Applicant: Dorchester Group

Proposal: Development of the Village Centre (south) comprising a Hotel and associated facilities (involving the partial demolition and the refurbishment and extension of Building 455 and its change of use); Bar/Brasserie (involving the partial demolition and refurbishment and extension of Building 457) and a Covered Market (canopy link between Buildings 455 and 457) with associated landscaping and car parking.

Committee Date: 27 October 2016 **Recommendation:** Approve

Ground Floor Plan

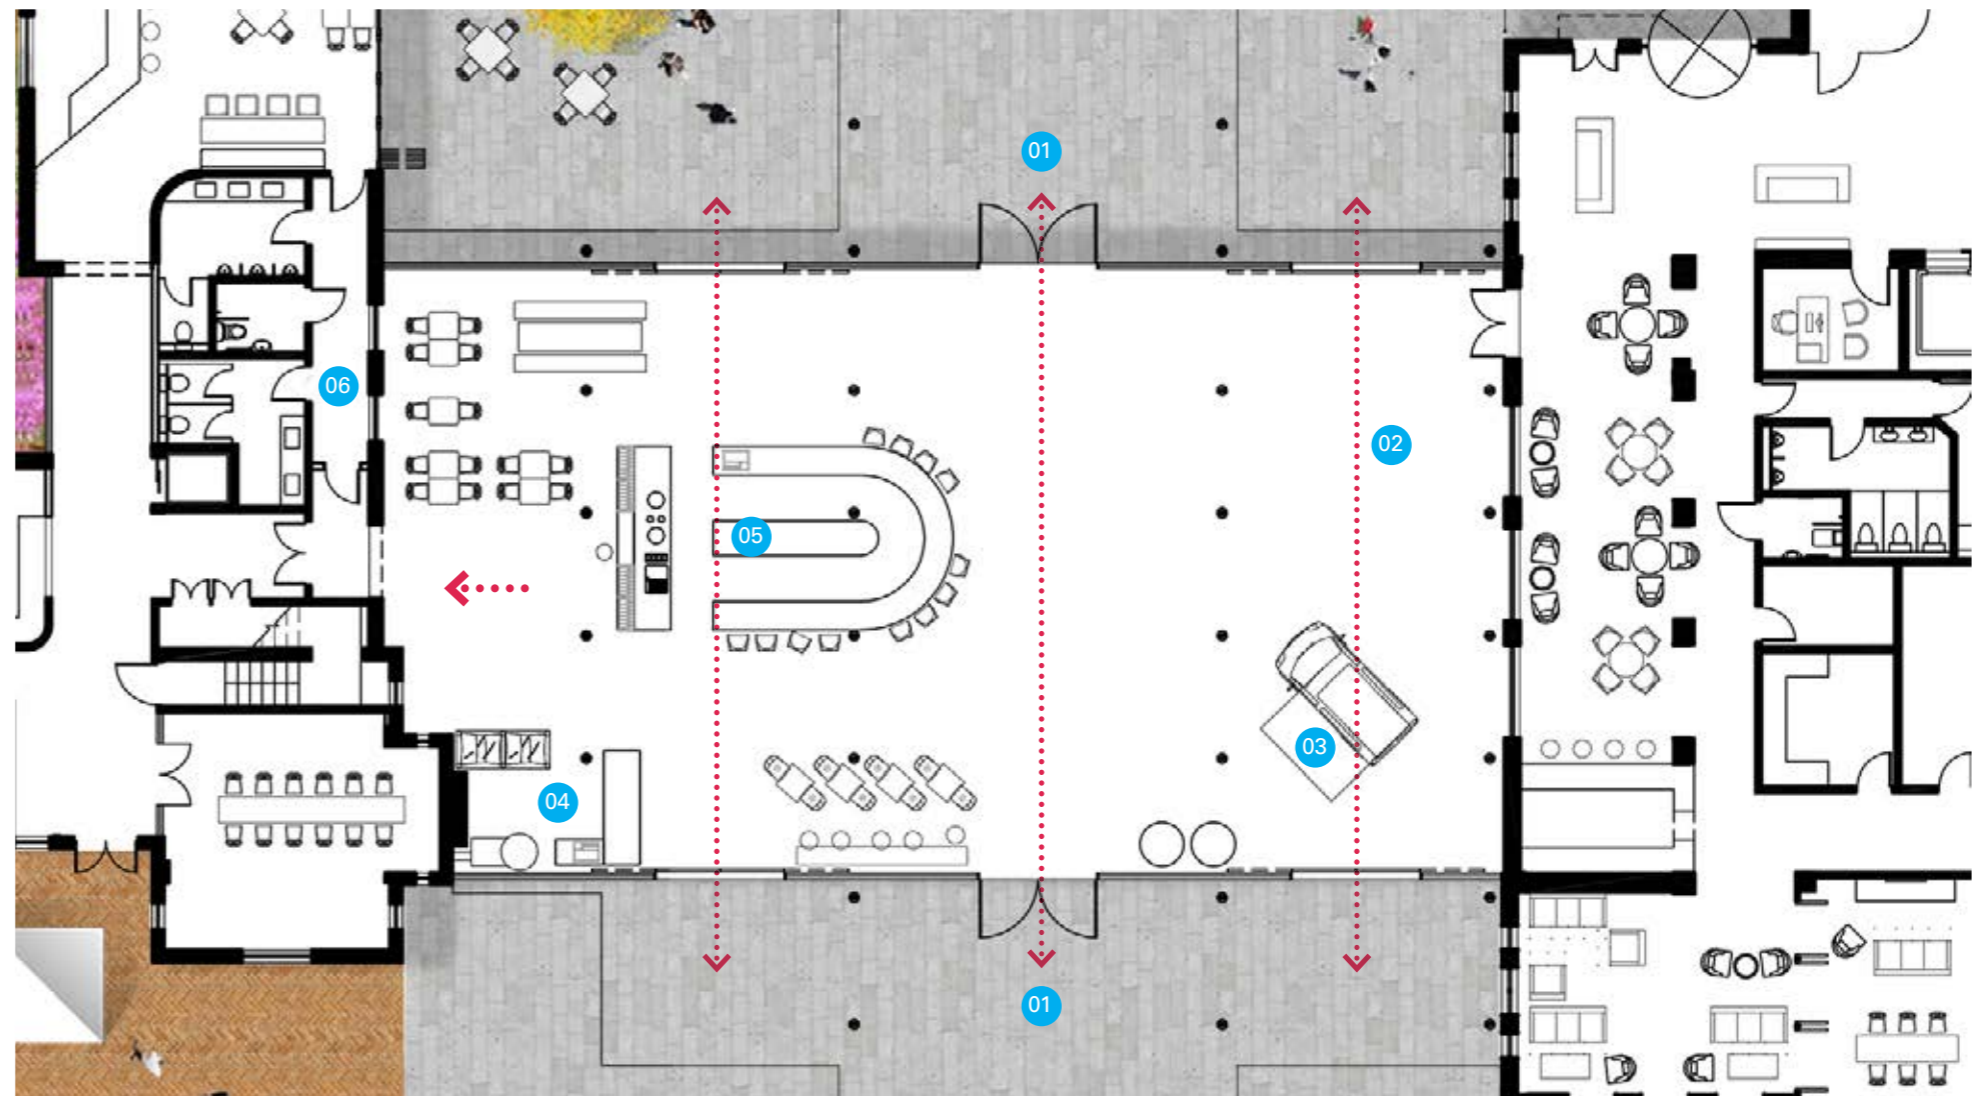
The north-south pedestrian route through the canopy link is an important connection. There should be a requirement that the through route will remain open outside commercially active hours. The statement that 'it is proposed that the covered market would be accessible circa early morning to late evening' (3.3 of the Planning Statement) is not specific enough and needs clarification.

Ground Floor Plan

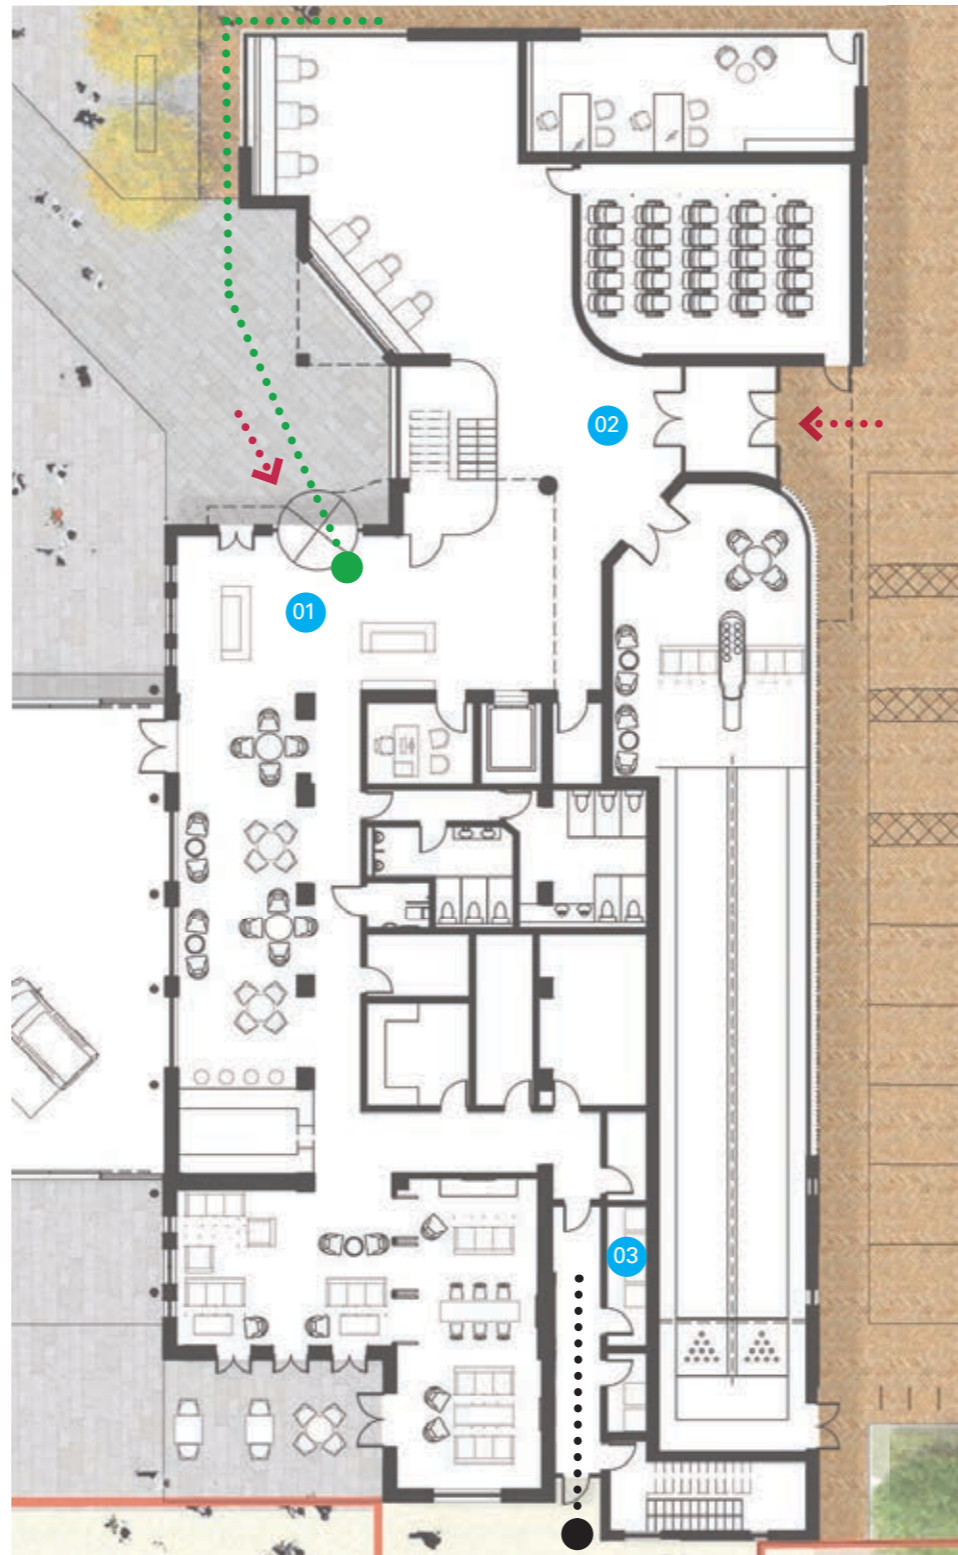
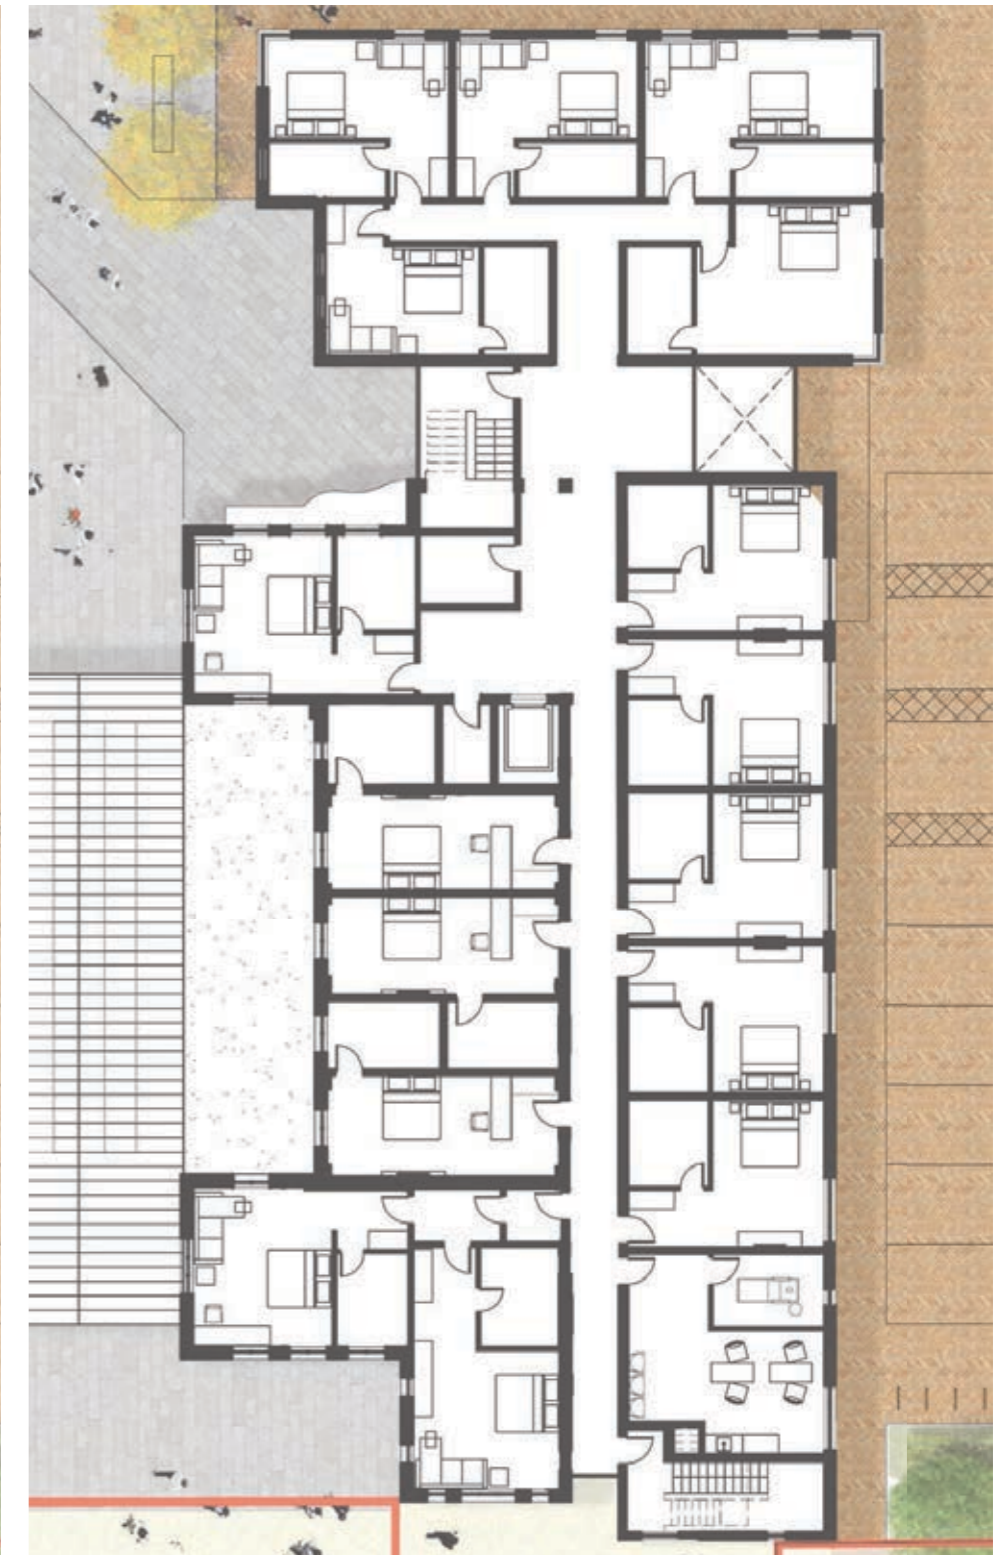
It is not clear whether the aluminium louvres to the ground floor eastern elevation of the extension to building 455 have glazing behind and will therefore offer some necessary surveillance of the car park & pedestrian route from the bowling alley.

The eastern elevation of building 455, the western and northern-western elevations of building 457 are not shown as 'active' but all face on to public areas and should be 'active' with good natural surveillance.

The internal refuse store to building 457 is located in an important corner location adjacent to the diagonal pedestrian route. This corner should be occupied by 'active' uses with windows/doors.

Car Park Plan

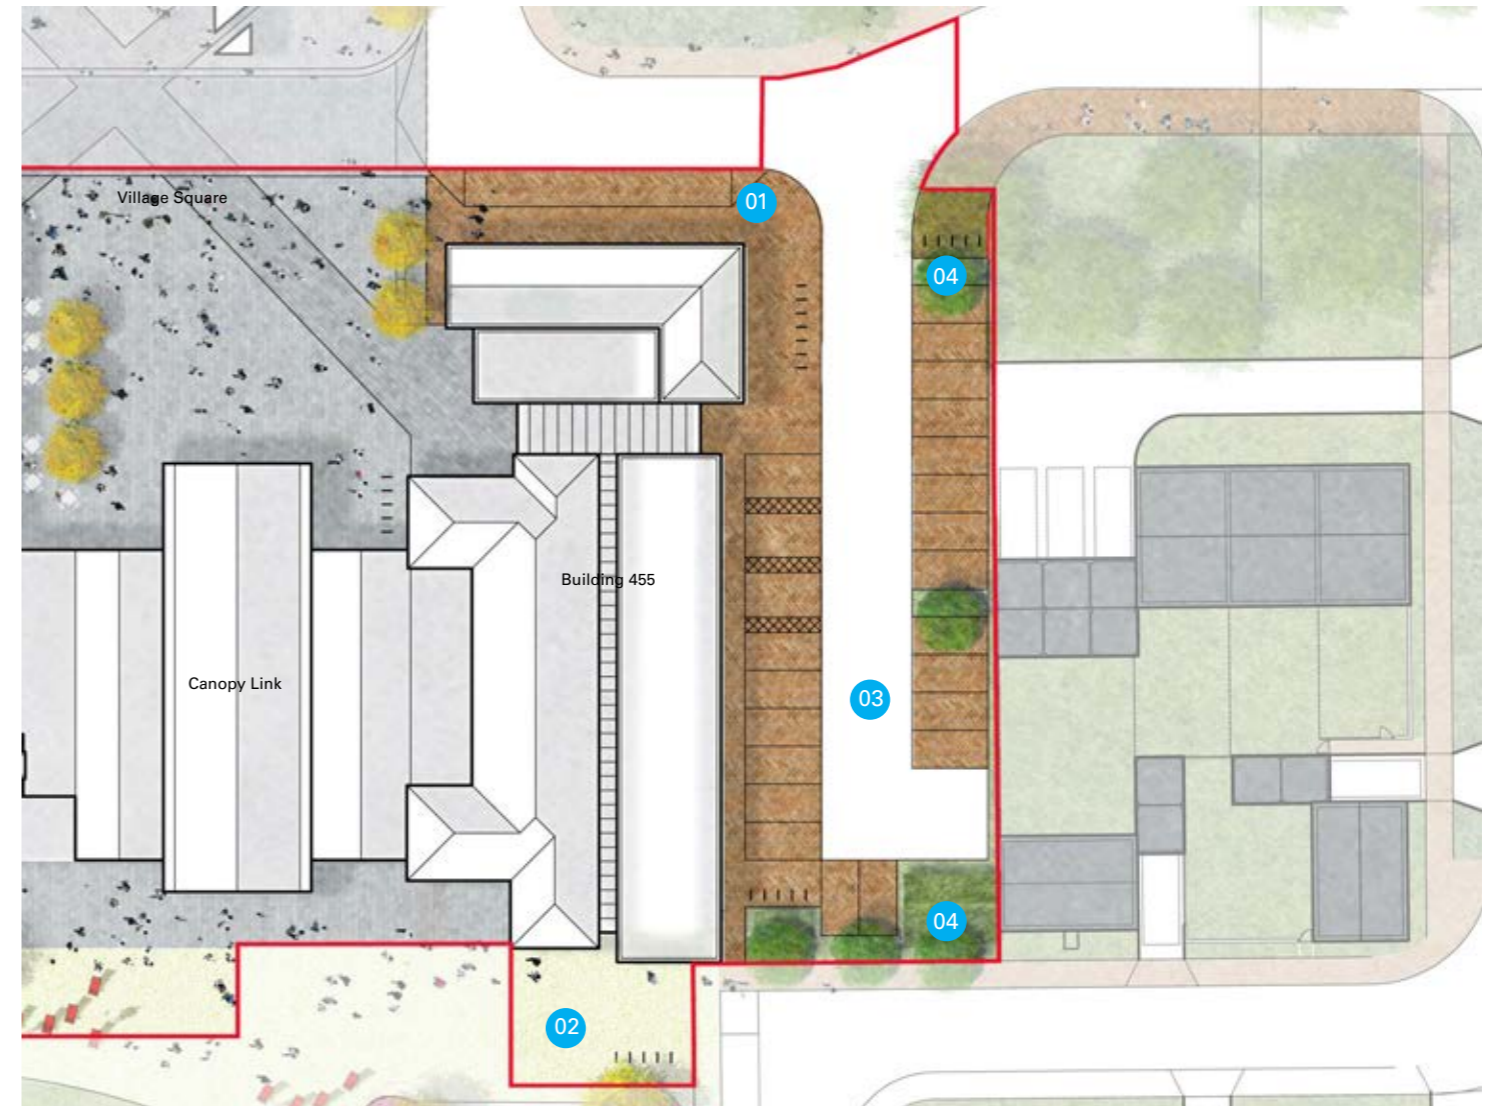
The 27 space car parking area exposes rear and side garden boundaries of residential property, making them less secure, and may compromise the ability to achieve a consistent built frontage to Camp Road.

The runs of parking bays should be broken up with trees.

Despite the indication of the tracking drawing the turning space is minimal.

The 34 space car park on the east side of building 455 should be broken up with trees and the view up the street on the eastern side of the 'village green' must not terminate with parked cars.

The 21 space echelon parking area is not very practical because of its single access/exit point despite the tracking drawing demonstrating that it is possible for vehicles to turn around, albeit on the diagonal pedestrian route.
